From: [REDACTED]
To: NorfolkVanguard@pins.gsi.gov.uk
Cc: catrin.jones@vattenfall.com; courtney.clemence@vattenfall.com; [REDACTED]
Subject: VATTENFALL NORFOLK VANGUARD - Registration identification number: 20012656 Oulton Parish Council
Date: 12 March 2019 22:18:24
Attachments: [Vattenfall Deadline 4 VISSIM screen prints.docx](#)

OPC welcome the opportunity to give an update at Deadline 4 on potential cumulative impact issues from Hornsea Three and Norfolk Vanguard projects at Oulton.

Cumulative Impact

Figure 1 – Hornsea Three, NV and NB (PEI) Project Boundaries

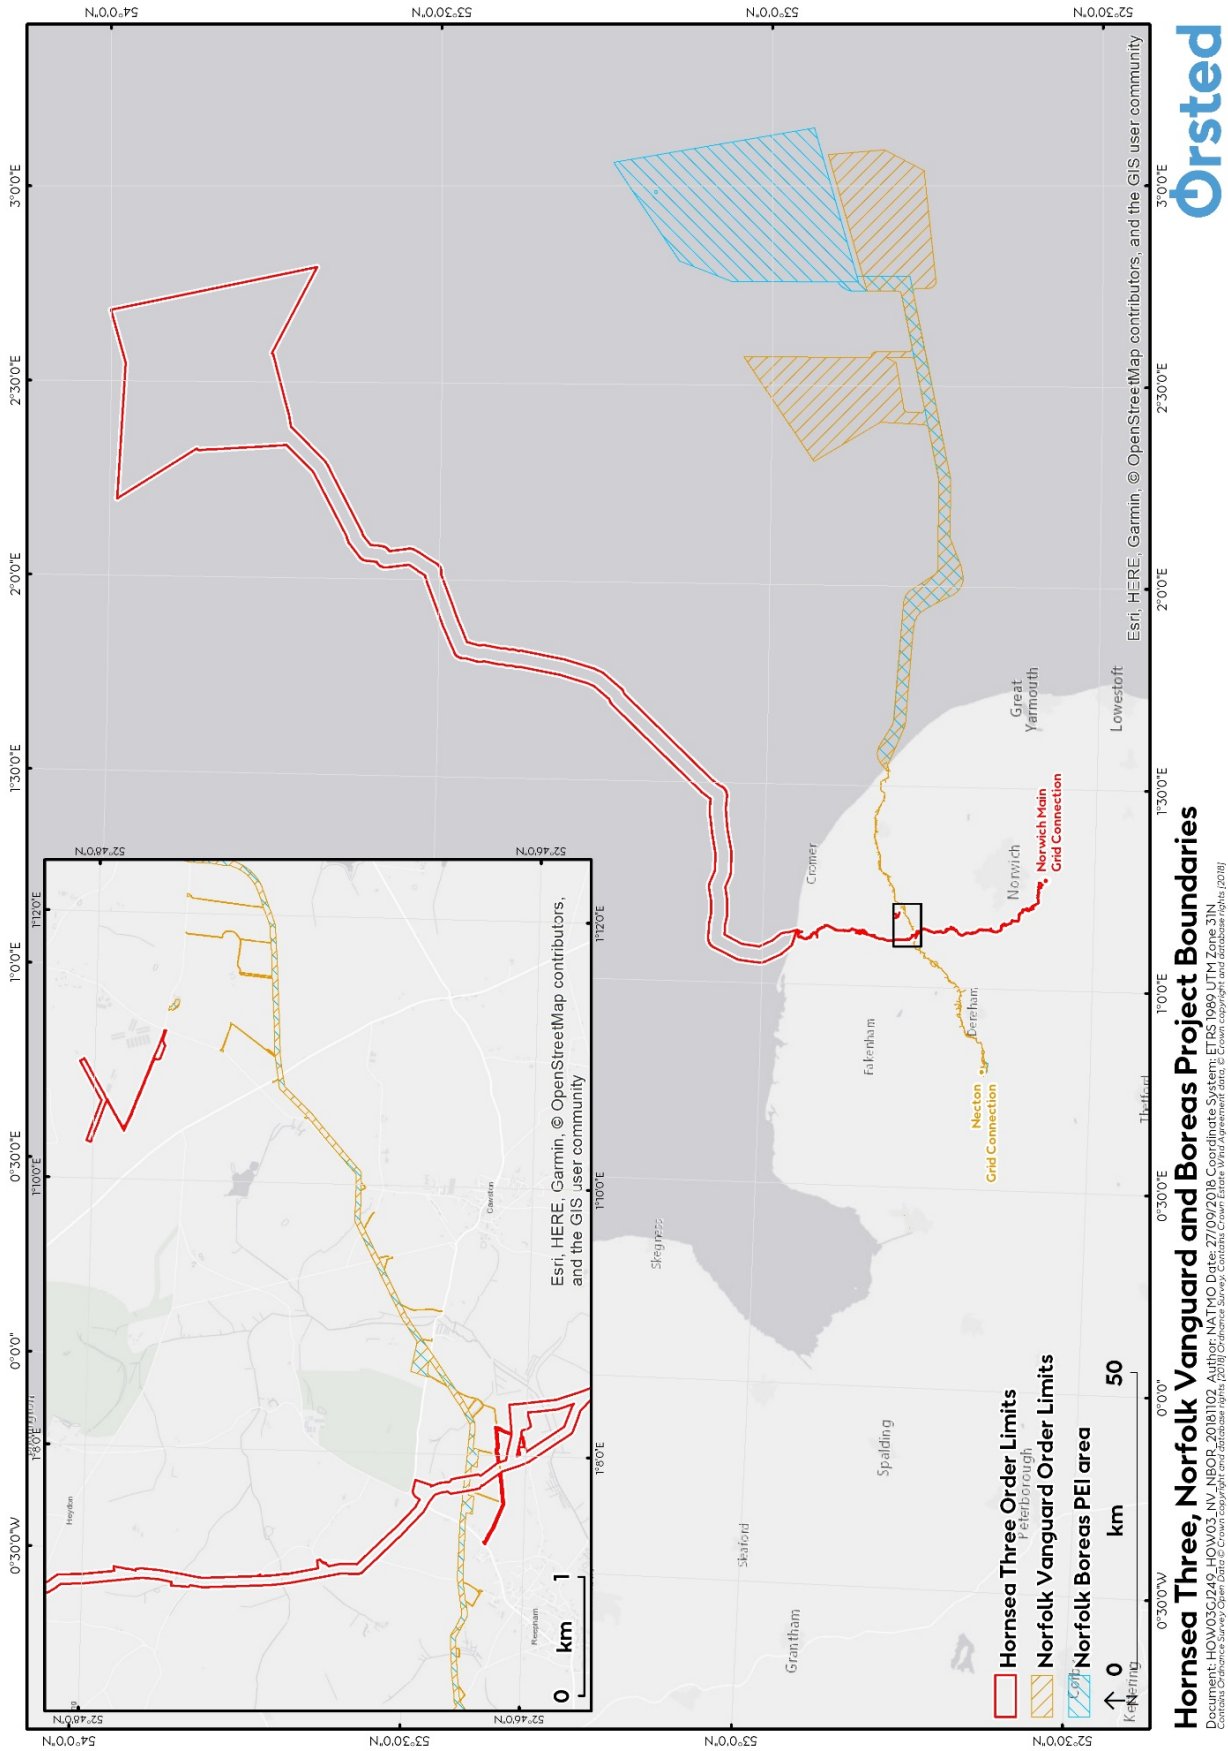
In light of the cumulative impact projections, OPC questions how Vattenfall Norfolk Vanguard will be able operate effectively along The Street with *no* mitigation measures similar to those proposed by Orsted, without significant highway disfunction.

Finally, OPC note that Vattenfall Norfolk Vanguard are **NOT** proposing to use trench-less crossing (HDD) at the point where the cable route crosses the B1149. OPC believes that section of the road is not wide enough to create single lane-controlled traffic movements safely. It is a busy well used route to and from Norwich. Given that the traffic for both projects will be accessing this section of road how will this be managed without serious traffic delays affecting the wider road network?

OPC would urge the applicant to reconsider this decision not to use HDD at this location and understand that NCC Highways are also very concerned about this aspect.
